## Appeal Decision

**Appeal Ref: APP/R4408/W/19/3230359**

**4 Church View Cottages, Sheffield Road, Wortley, Barnsley S35 7DB**

- The appeal is made under section 78 of the Town and Country Planning Act 1990 against a refusal to grant planning permission.
  - The appeal is made by Mr Orme on behalf of Wharncliffe Estates Ltd against the decision of Barnsley Metropolitan Borough Council.
  - The application Ref 2019/0242, dated 21 February 2019, was refused by notice dated 24 May 2019.
  - The development proposed is change of use of agricultural land (approx. 95sqm) for use as vehicular driveway to no 4 Church Cottages.
-

TITLE  
**PROPOSED VEHICLE  
ACCESS**

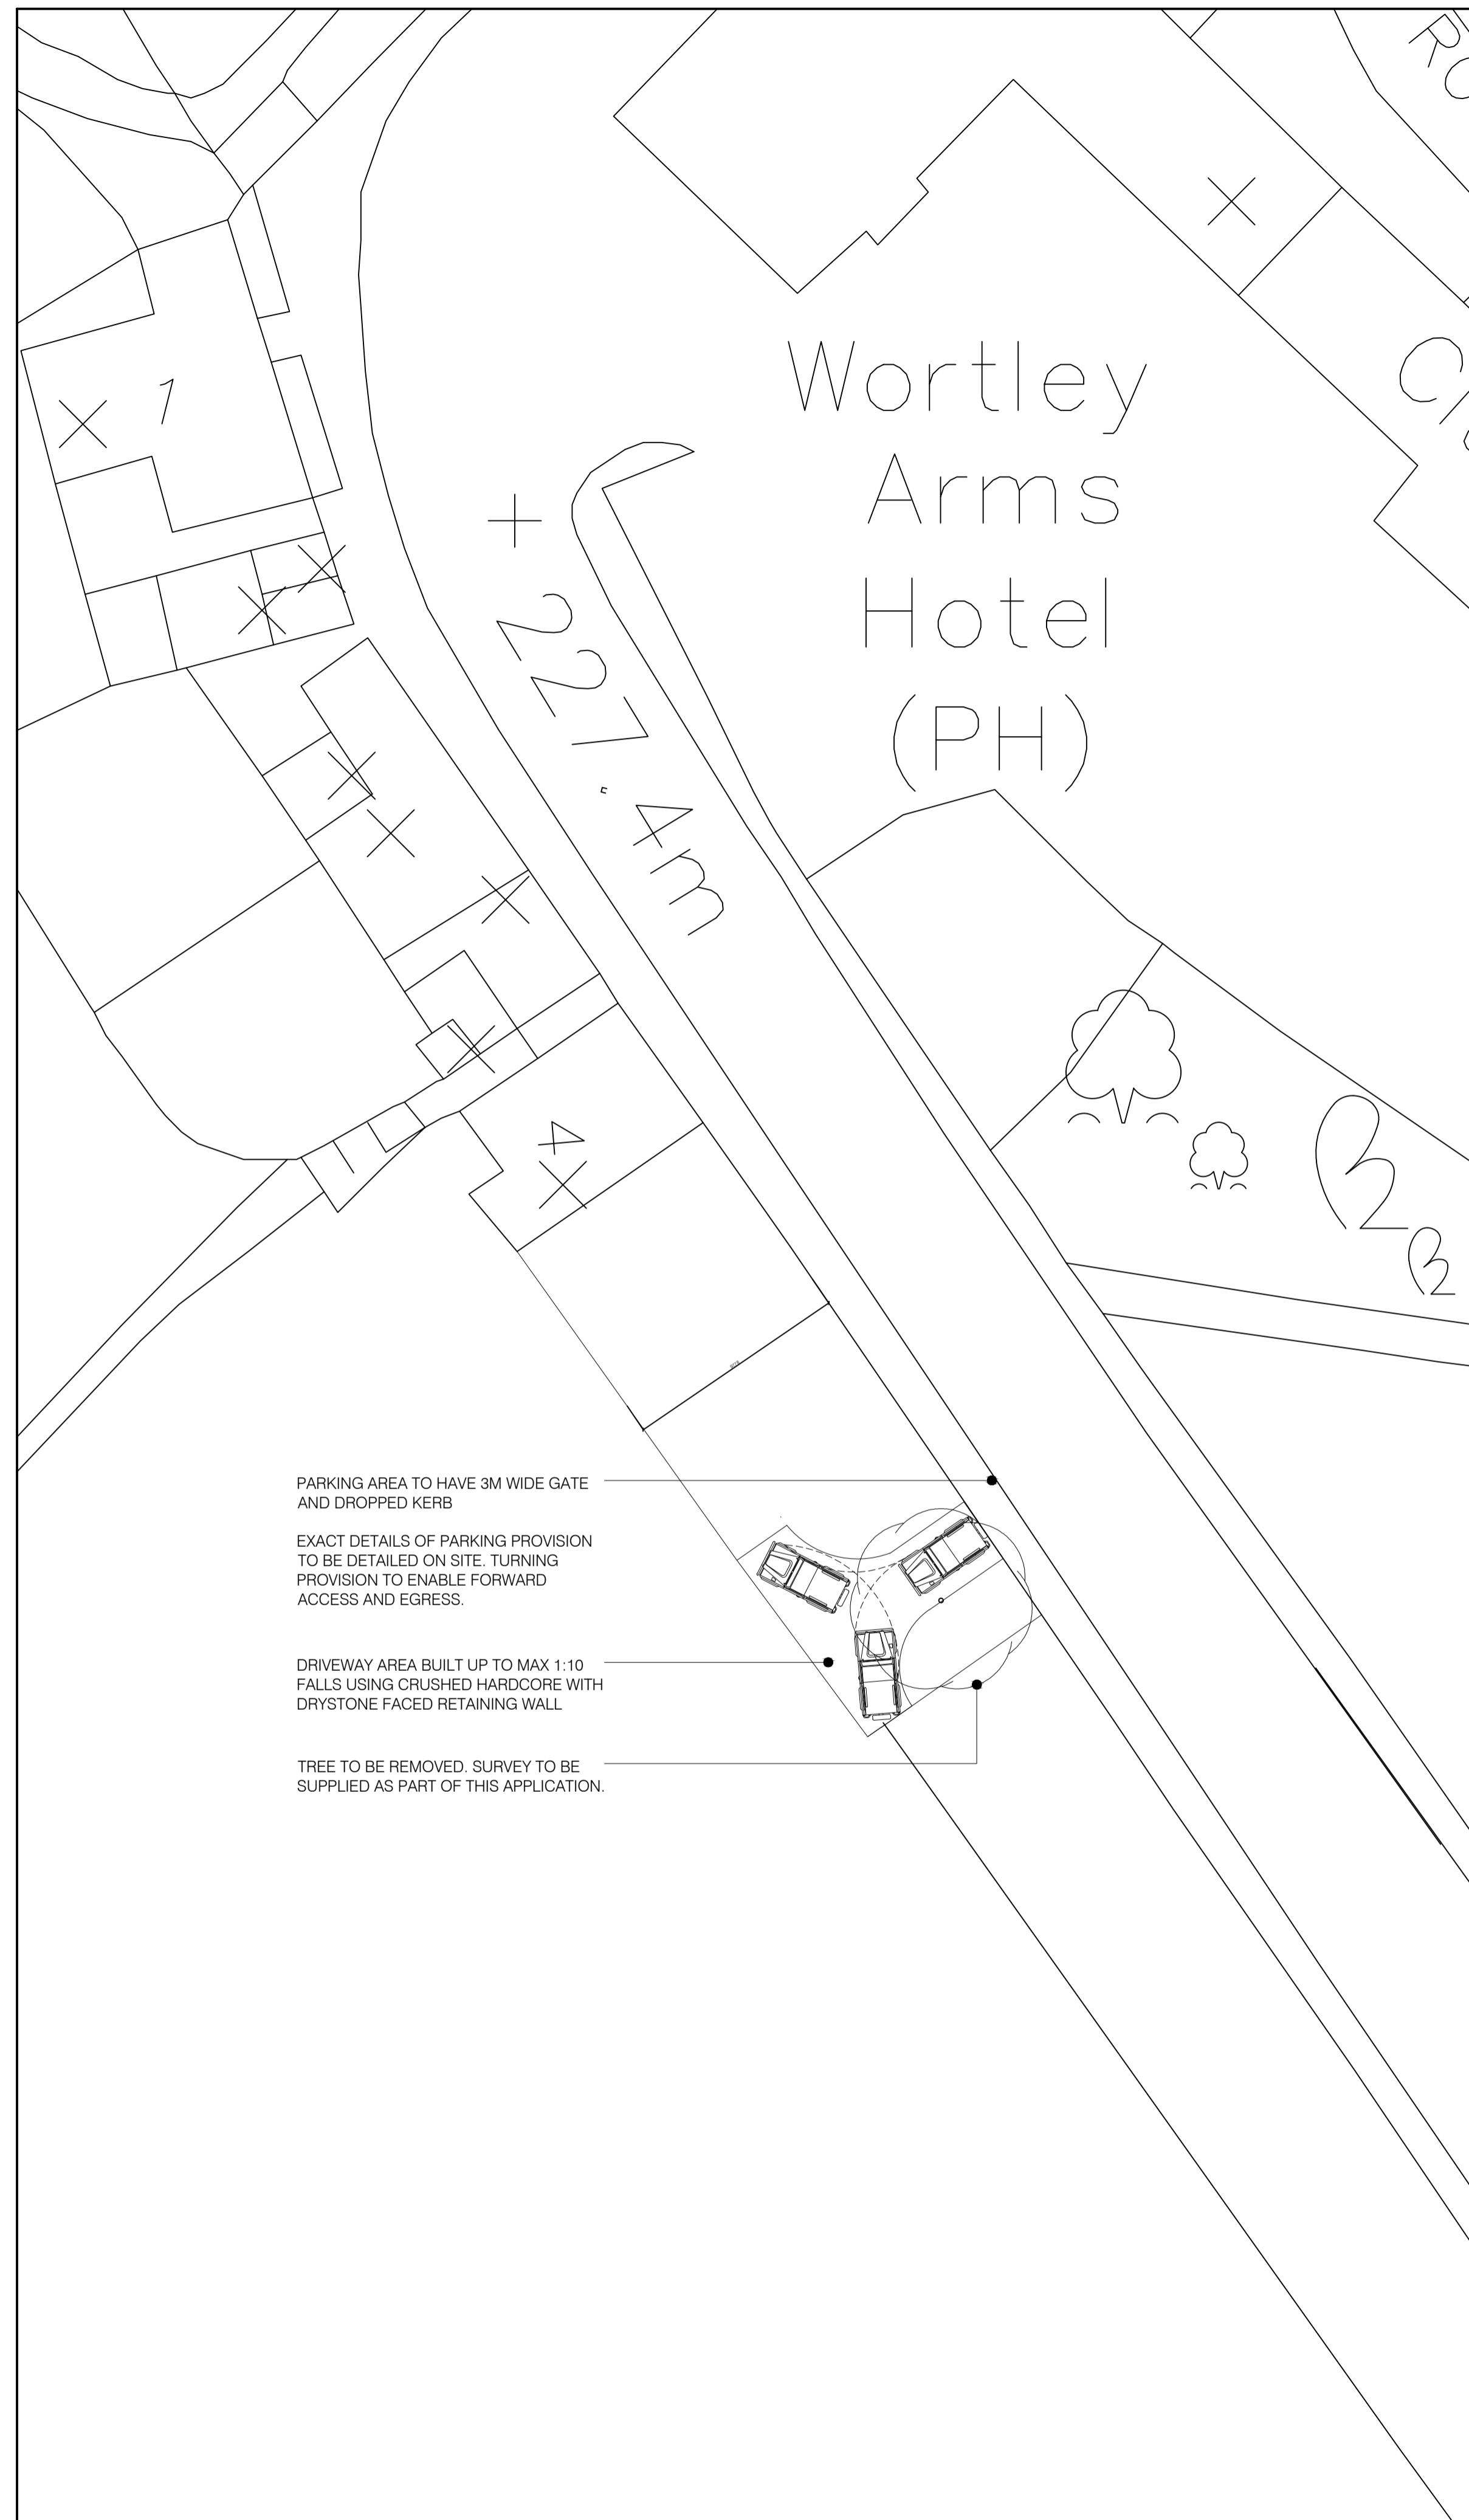
9. The driveway would also have to be built up to create a level area in which vehicles could turn and access the highway. This would necessitate the removal of a tree and a section of the boundary wall. Given that the adjacent field slopes down to the west with long views to the countryside beyond, the elevated location of the proposal would consequently be visible to the wider area. It would result in a permanent change to the character of the landscape and it would be visually harmful to the openness of the Green Belt as a result.

13. The appeal site would occupy a reasonably prominent position at the entrance to the village and to the CA, with the Grade II Listed Park and Gardens close by. This approach is characterised, in part, by the consistency of the dry-stone wall adjacent to the pavement along the side of the A629, which is unbroken within the immediate vicinity of the site. However, to provide the access to the driveway, the proposal would result in the removal of a 3m section of it. As a result, the continuity of the stone boundary wall would be lost.

21. Moreover, even though the site plan indicates that it would be possible to turn a car within the site, I am mindful of the consultation response from the Council's Highways Development Control Officer, upon which the appellant has had the opportunity to comment, that it would not accommodate a standard size vehicle. I appreciate that the appellant has shown a car that has a turning circle of 5.75m radius and cites two specific makes of vehicle. However, I have nothing before me to demonstrate that these would be standard size vehicles or that it could accommodate a larger vehicle. In any event, the turning area would appear constrained by the depth of the site. Consequently, the turning manoeuvres of vehicles entering and leaving the site would be likely to lead to conflict and inconvenience to highway users.

22. Furthermore, even if a material other than gravel were used to surface the driveway or the gravel were contained by a 'sleeping policemen' arrangement, the 1:10 fall indicated on the site plan would conflict with the maximum gradient of 1:12 permitted by guidance within the South Yorkshire Residential Design Guide (SYRDG) (2011). This would impact upon the speed at which vehicles could access and egress the driveway.

23. I acknowledge the appellant's contention that the site plan should have read 1:12 and that a condition could be attached to require that this gradient be achieved. However, this would result in the land being built up further. On the limited evidence before me, in the absence of any cross-sections or level details, I cannot determine with any certainty the extent to which it would make it substantially different from that set out in the application. In this
